Tyrrells Land, Stradbally Road,
Portlaoise, Co. Laois

Case reference: JP11.323606

Response to An Coimisiún Pleanála Comments

Proposed Development of 67 No. Housing Units at Tyrrells Land, Stradbally Road, Portlaoise

Figure 5.5: Proposed Stradbally Road/ Internal Access Road junction Layout (Source: Van Dijk Architects)

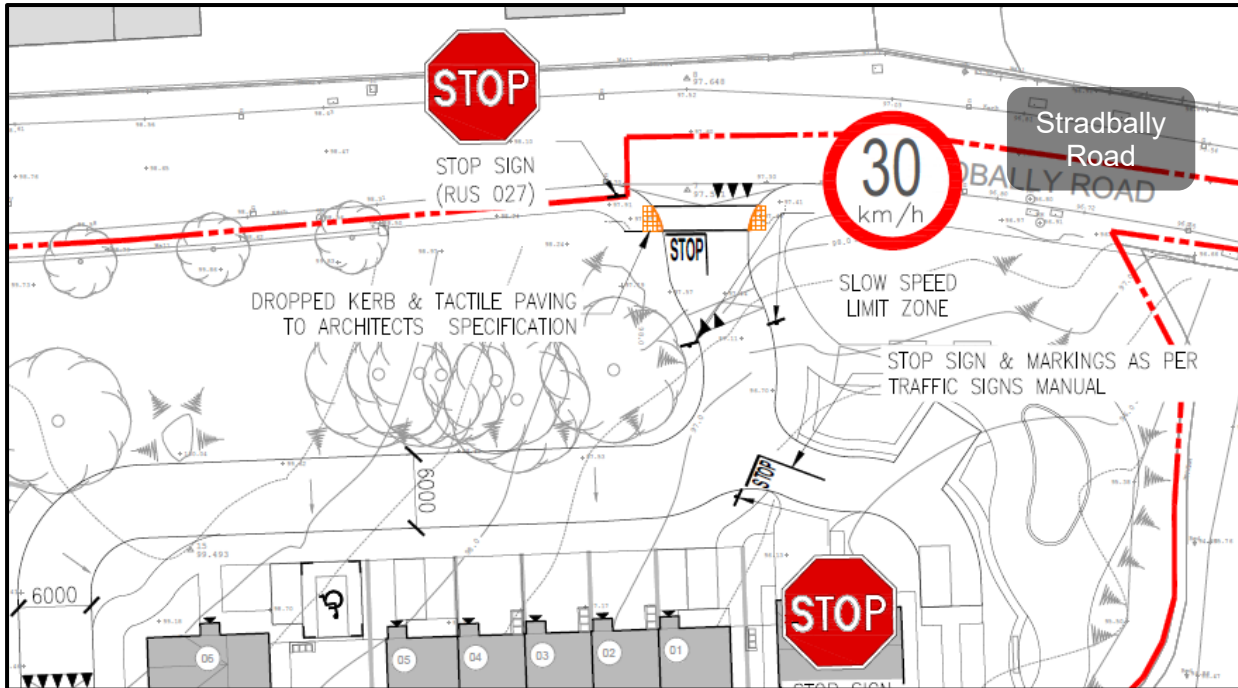
TII note that a Design Report may be required for the new junction.

3. Junction Design

- A Design Report can be prepared as a planning condition, which is common for urban residential schemes interfacing with national secondary routes.
- Any refinements arising from the Design Report can be incorporated post-permission without altering the site layout.

- To clarify, the site is located within the town centre and lies within the urban 50 km/h zone not a 60km/h speed zone.
- Matches existing access patterns along this section of the N80
- Meets all relevant visibility and safety criteria
- Will be supported by a technical note confirming compliance with TII standards
